SICEEP – North West Plot SSDA4 - Response to Public Submissions

SICEEP - SSDA4 Shadow Study

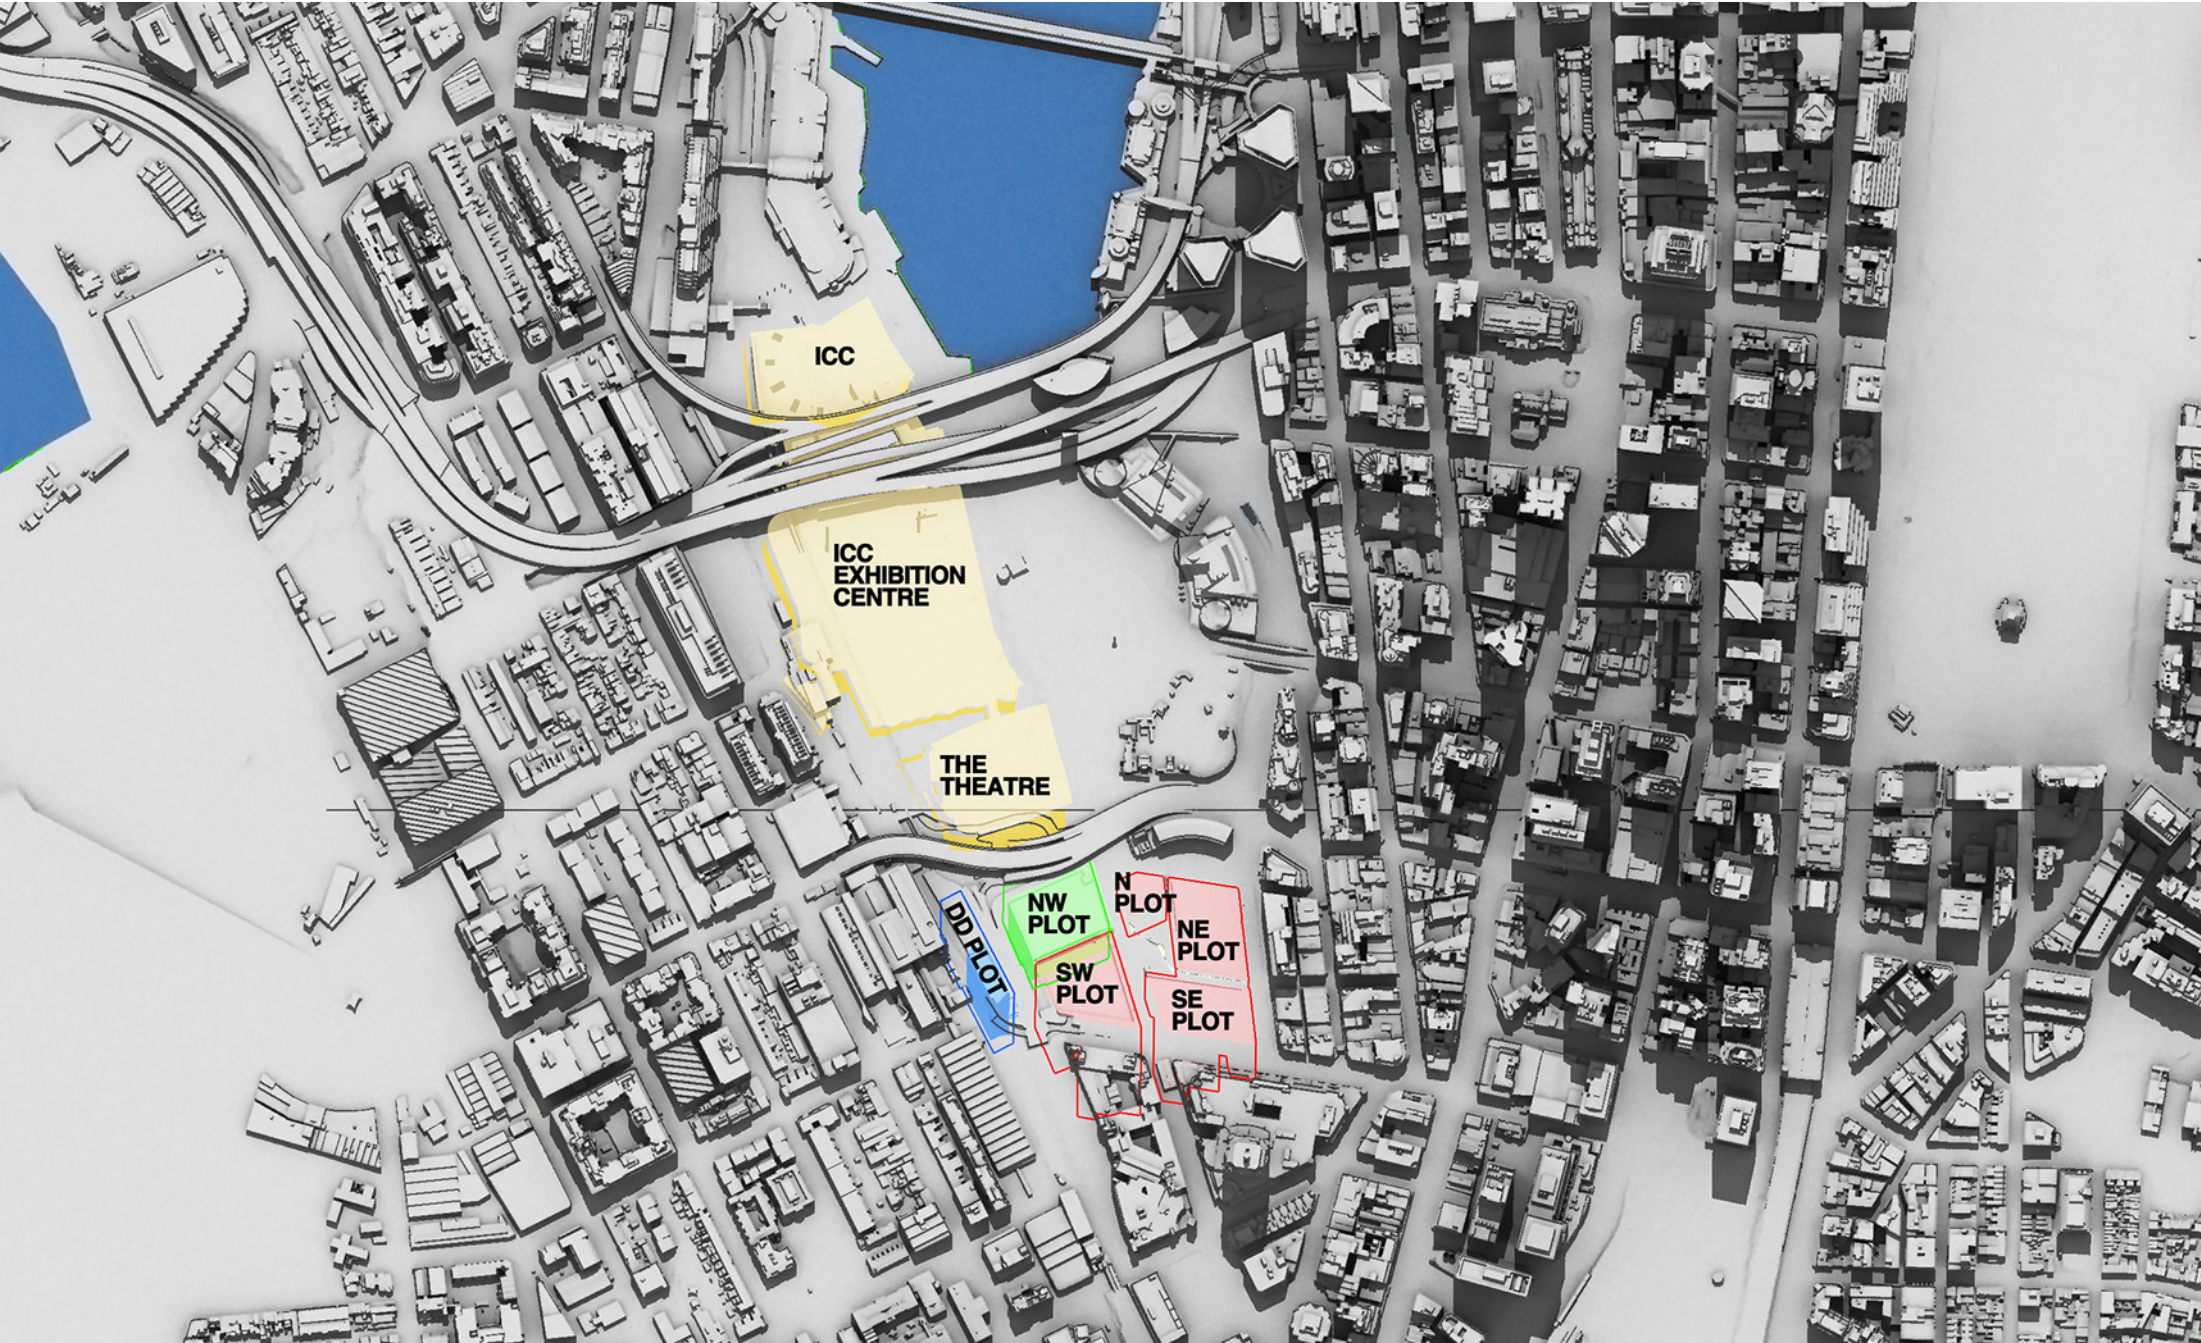
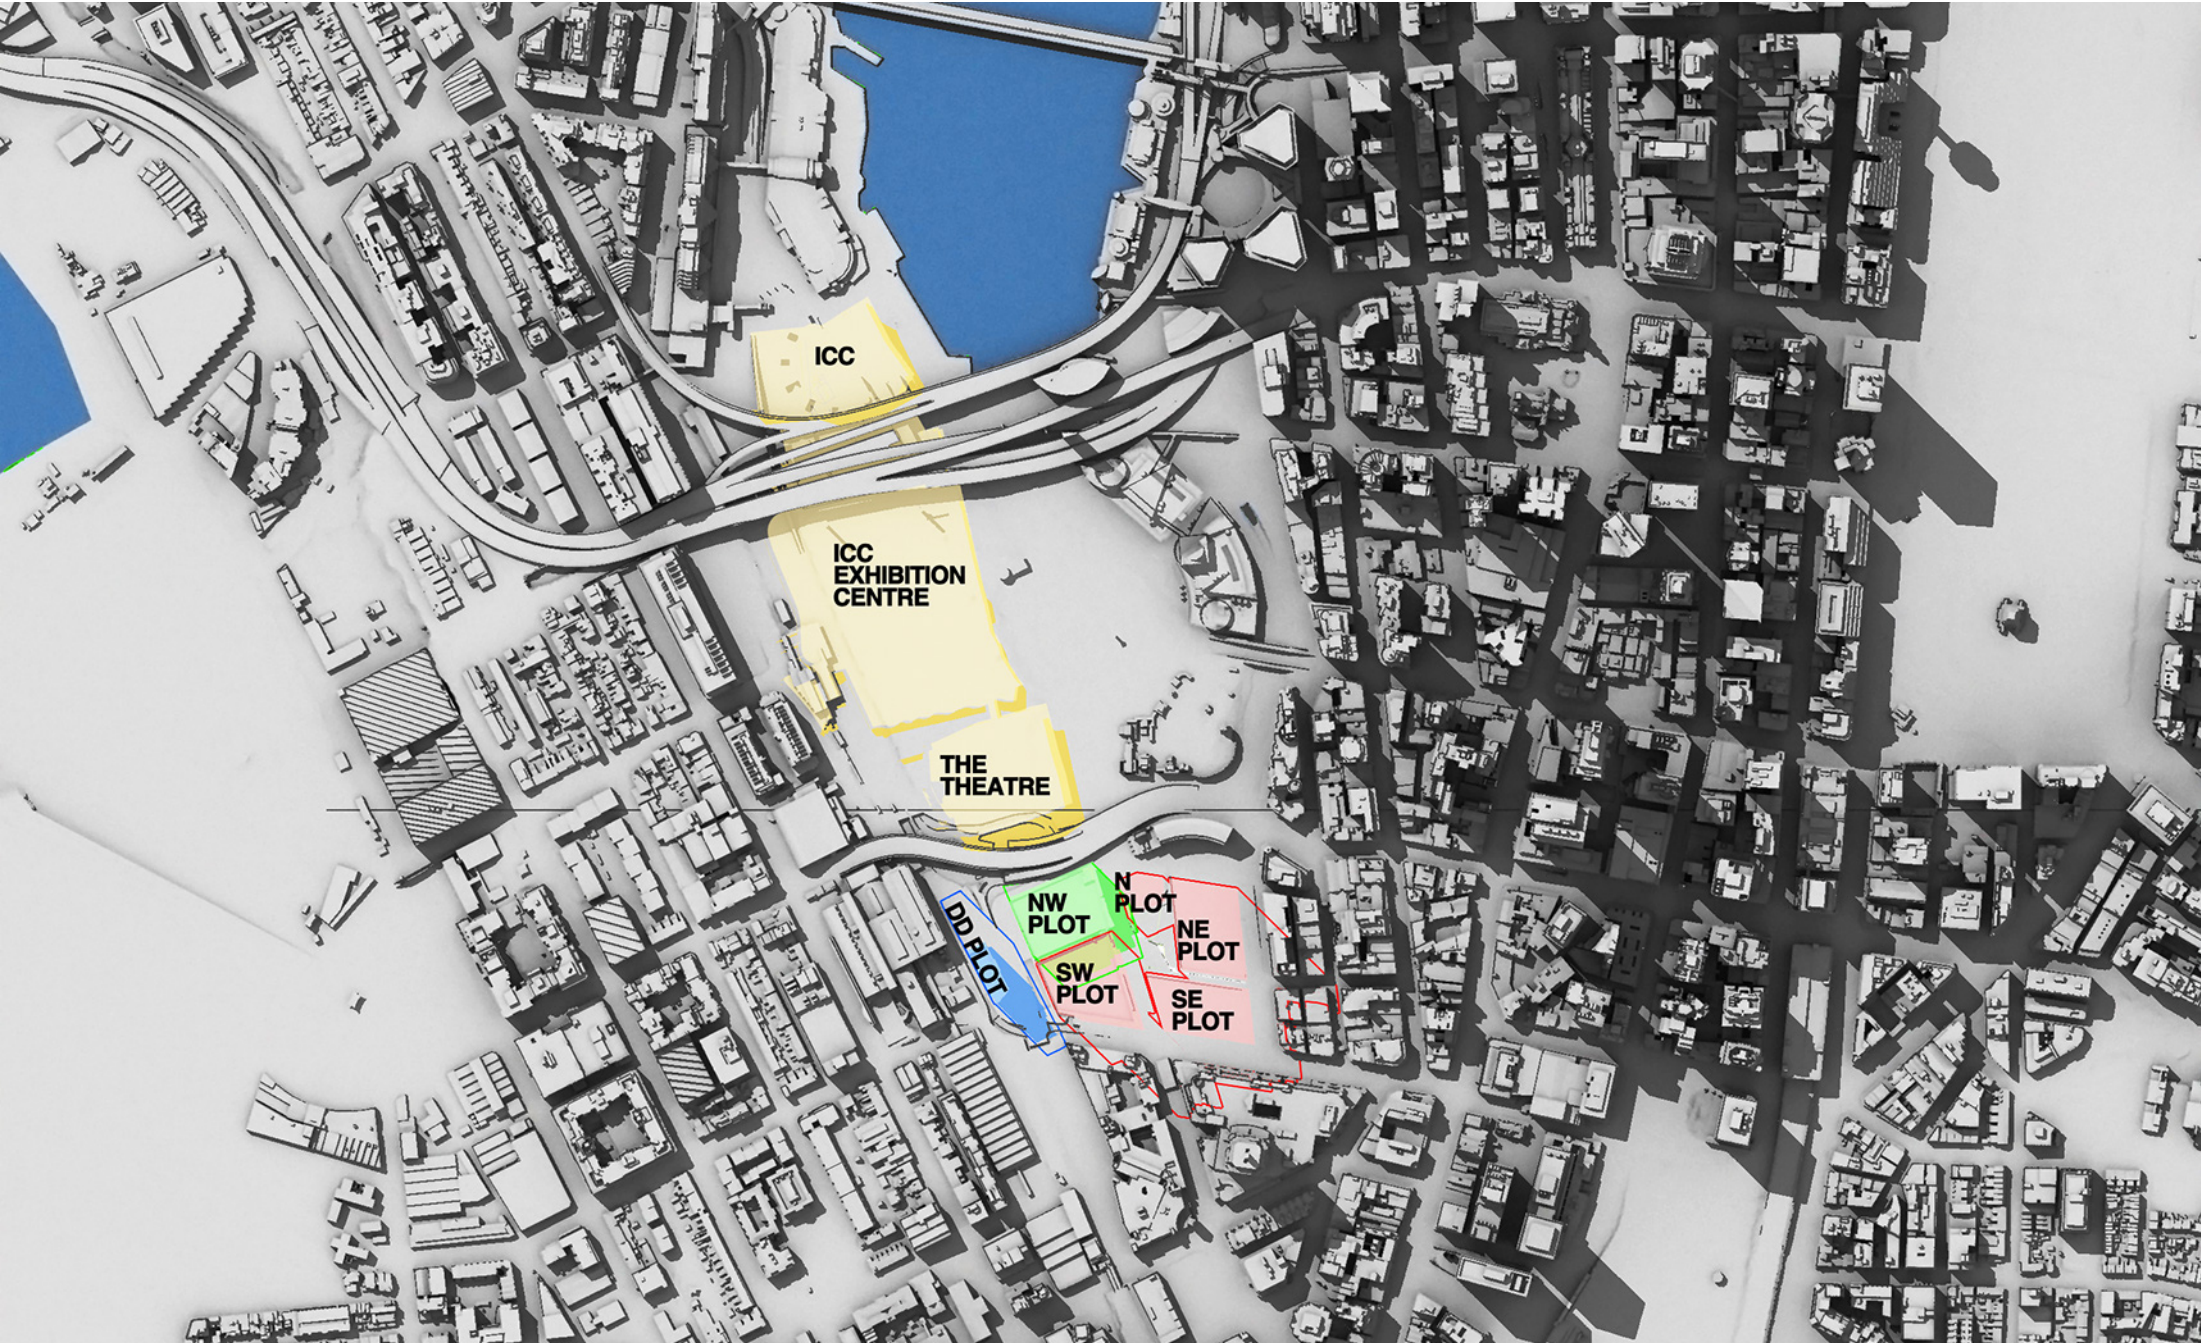
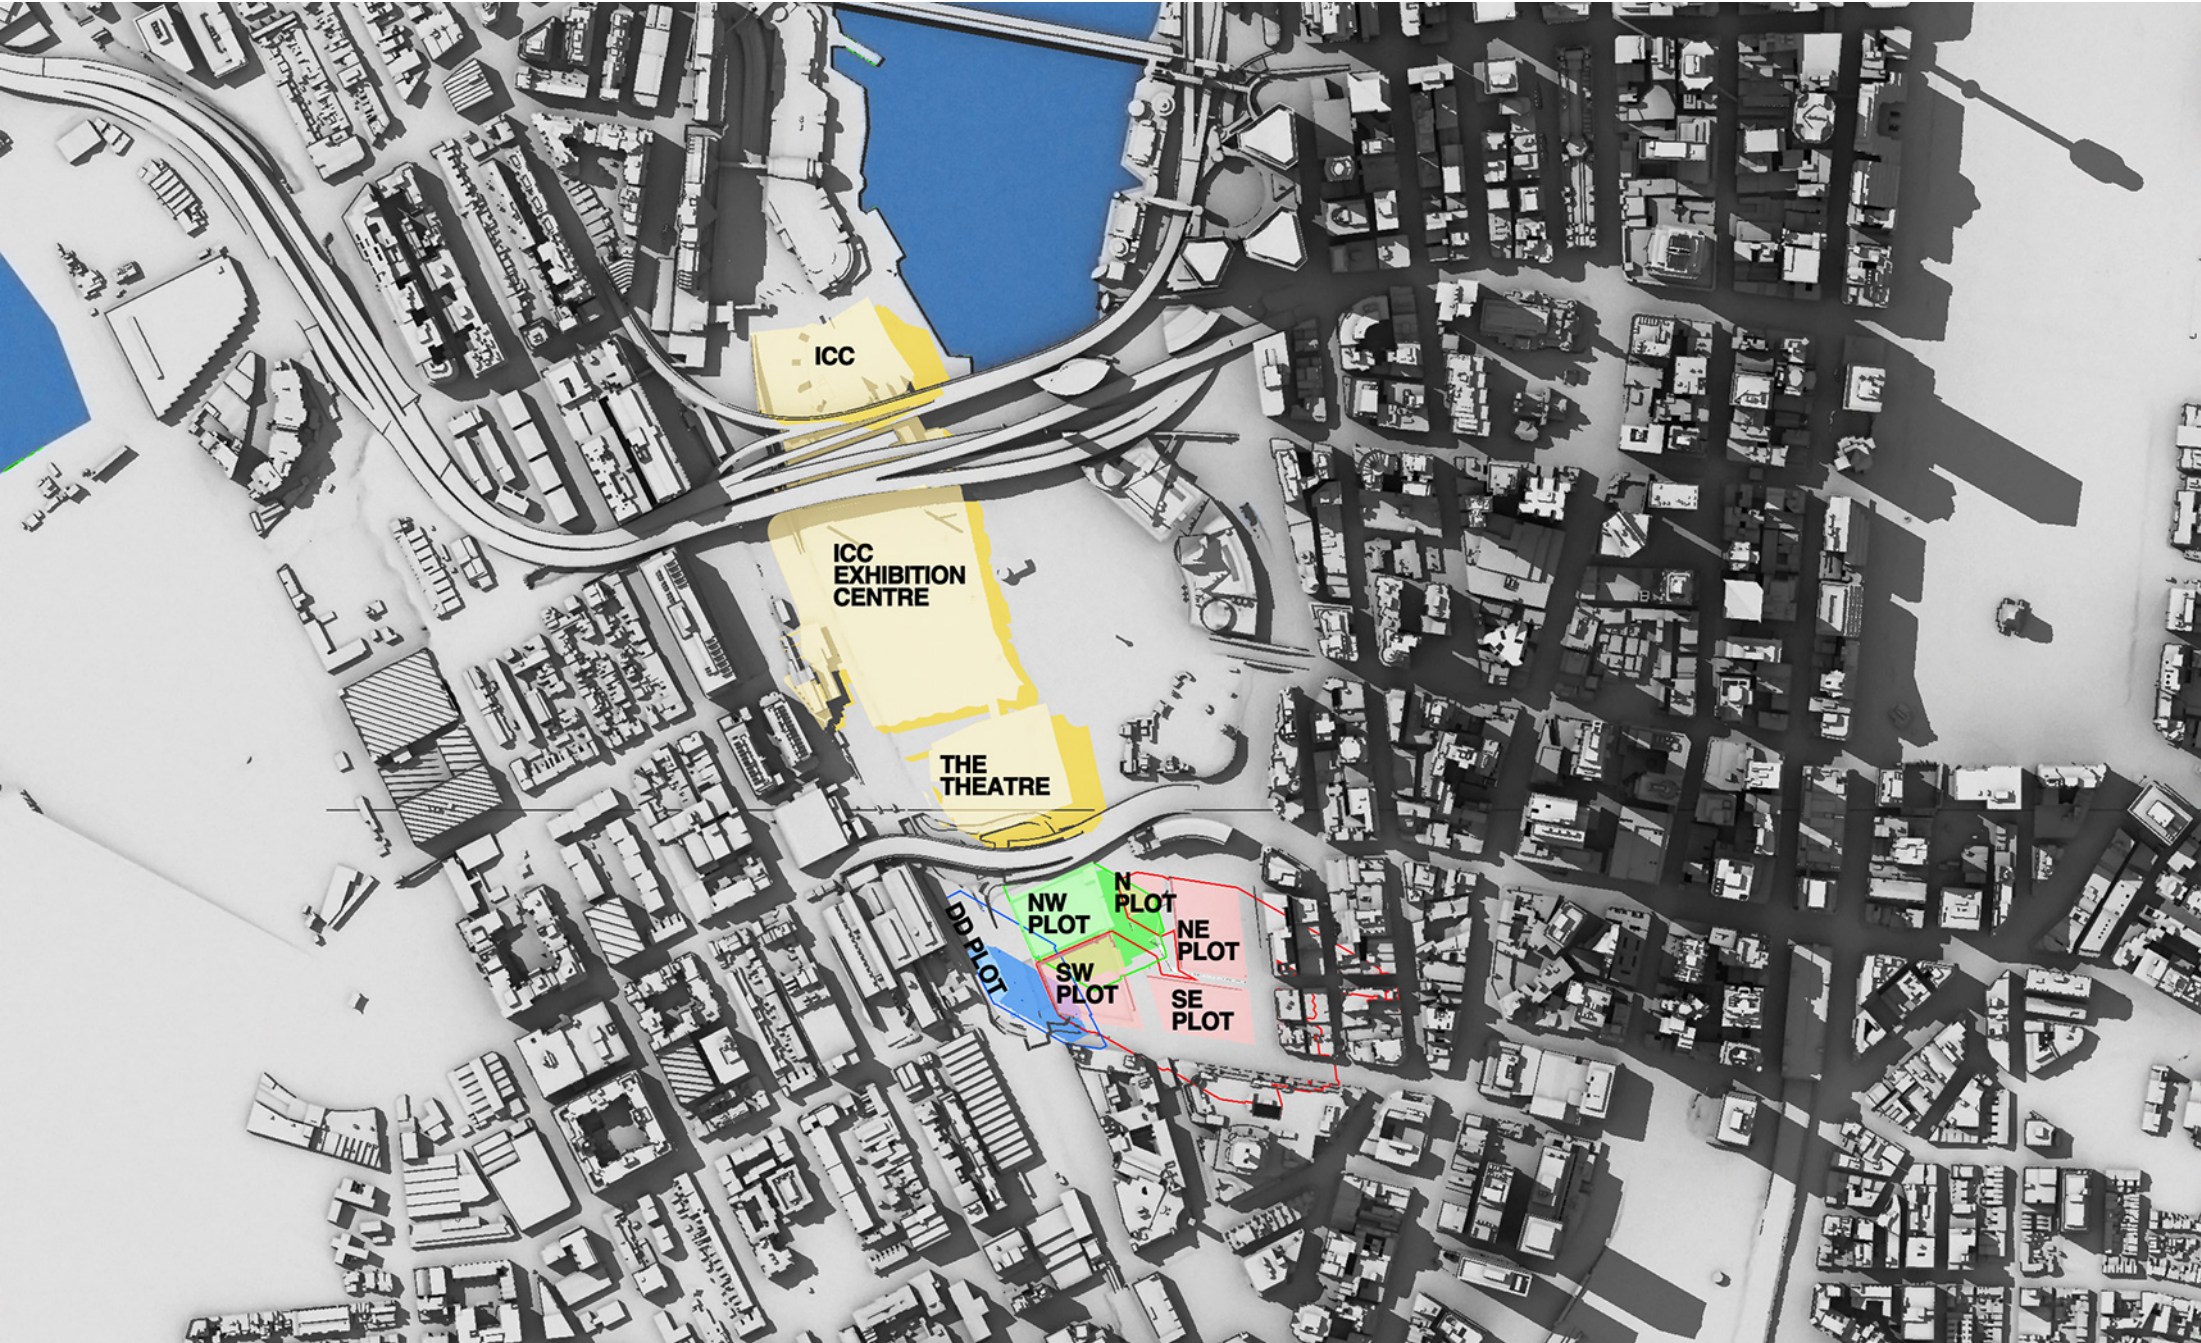
Number of times raised in Submissions	Item Raised	Proponent's Response
Overshadowing		
2	Contrary to the requirements of the City of Sydney Development Control Plan 2012 (DCP), the overshadowing diagrams in the original EIS were in plan only (Appendix J, pages 74-80). The original EIS did not include any overshadowing diagrams in elevation. Therefore it was impossible to assess the extent of overshadowing of individual neighbouring dwellings within tall buildings, ie The Peak and The Quay. The elevation studies have now been belatedly provided during the Stage 2 SSD's exhibition phase and meaningful public response is now possible for the first time. For some reason, exhibition of the Stage 2 SSDs did not wait until the revised EIS was publicly available. Therefore although this submission is being made in response to the Stage 2 SSDs, it necessarily focuses on the shadow diagrams in the revised SSD 5878. It is important to note that those elevation studies do flow through to each of the Stage 2 SSDs. As at the date of this submission, SSD3010, SSD6011 and SSD6013 are the only SSDs on exhibition for The Haymarket site.	There was no statutory requirement as part of the submission of the Stage 1 Development Application (SSD_5878) to prepare and submit elevational shadowing diagrams, noting that the Sydney DCP does not apply to the SICEEP site. Notwithstanding and in response to submitters and the Department of Planning and Infrastructure, detailed shadow diagrams were subsequently prepared illustrating the shadows cast by the Haymarket Concept Proposal on the facades of the Peak Apartments building. The shadow studies revealed that the extent of additional overshadowing as a result of the Concept Proposal (including the North West Plot which accommodates the subject mixed use commercial office building and public car park) is appropriate and reasonable. This conclusion was subsequently agreed with and supported by the Department of Planning and Infrastructure, with the Stage 1 Concept Proposal (SSD_5878) approved on 5 December 2013. With the subject State Significant Development Application (SSD_6013) being wholly contained within the approved building envelope for the North West plot, the overshadowing impacts resulting from the proposed Mixed Use Commercial Office Building and Public Car Park are appropriate and consistent with the Stage 1 approval.

2	The assertion made within SSD5878 Response to Submissions and Amendments to Proposed Development Report, July 2013, that the apartments on the northern and western elevations of the building are dual aspect is incorrect. Only corner apartments are dual aspect, with levels of the tower containing single aspect apartments on all elevations.	Noted. Notwithstanding the proportion of single aspect apartments within the Peak building, the level of additional overshadowing impacts remains acceptable as demonstrated within the detailed shadow studies submitted in support of the Stage 1 Concept Proposal (SSD_5878). This conclusion was subsequently agreed with and supported by the Department of Planning and Infrastructure, with the Stage 1 Concept Proposal (SSD_5878) approved on 5 December 2013.

Number of times raised in Submissions	Item Raised	Proponent's Response
2	It is disappointing that at this late stage in the development application process, despite numerous site visits by the proponent, and despite the apartment aspects being publicly available from NSW Land and Property Information, the proponent is still unaware of the actual apartment aspects within The Peak. In total there are 110 apartments in The Peak with single aspects which are either west only or north only. 110 apartments with single aspects which are either west only or north only is hardly a negligible number whose existence can be falsely denied by the proponent.	Noted. Notwithstanding the proportion of single aspect apartments within the Peak building, the level of additional overshadowing impacts remains acceptable as demonstrated within the detailed shadow studies submitted in support of the Stage 1 Concept Proposal (SSD_5878). This conclusion was subsequently agreed with and supported by the Department of planning and Infrastructure, with the Stage 1 Concept Proposal (SSD_5878) approved on 5 December 2013.

2	The proponent provides diagrams but fails to discuss the existing shadowing of the west façade of The Peak. The proponent provides diagrams but fails to discuss the combination of the proposed development with existing shadowing of the west façade of The Peak. It can be concluded that, as a result of combination of the proposed development with existing shadowing of the west façade, some single aspect apartments on the west façade and the south-west dual aspect corner apartments which currently receive less than 2 hours direct sunlight to habitable rooms and 50% of the private open space between 9am and 3pm on 21 June will suffer additional overshadowing. Rather than counting the number of units which will not meet the DCP guidelines, the proponent attempts to trade-off direct sunlight at 4pm for lack of direct sunlight during the period 9am to 3pm. There is no provision in the DCP guidelines for such a trade-off.	The Sydney DCP does not apply to the SICEEP site. The existing shadow impacts caused by the Peak building itself on apartments, in particular apartments on the southern and western elevations are noted. An assessment was undertaken in relation to the direct additional overshadowing impacts resulting from the Concept Proposal, with the results revealing that impacts would be acceptable and that apartments within the Peak would continue to receive an acceptable level of sunlight/daylight. In addition, we note that solar access is but one consideration in terms of residential amenity, with other equally important aspects to residential amenity (as prescribed under the Residential Flat Design Code) including views, outlook, access to services, transport, jobs etc. Therefore, notwithstanding some additional (acceptable) overshadowing impacts to apartments on the western elevation of the Peak building, these need to be considered holistically in terms of the other aspects of residential amenity afforded to these apartments.
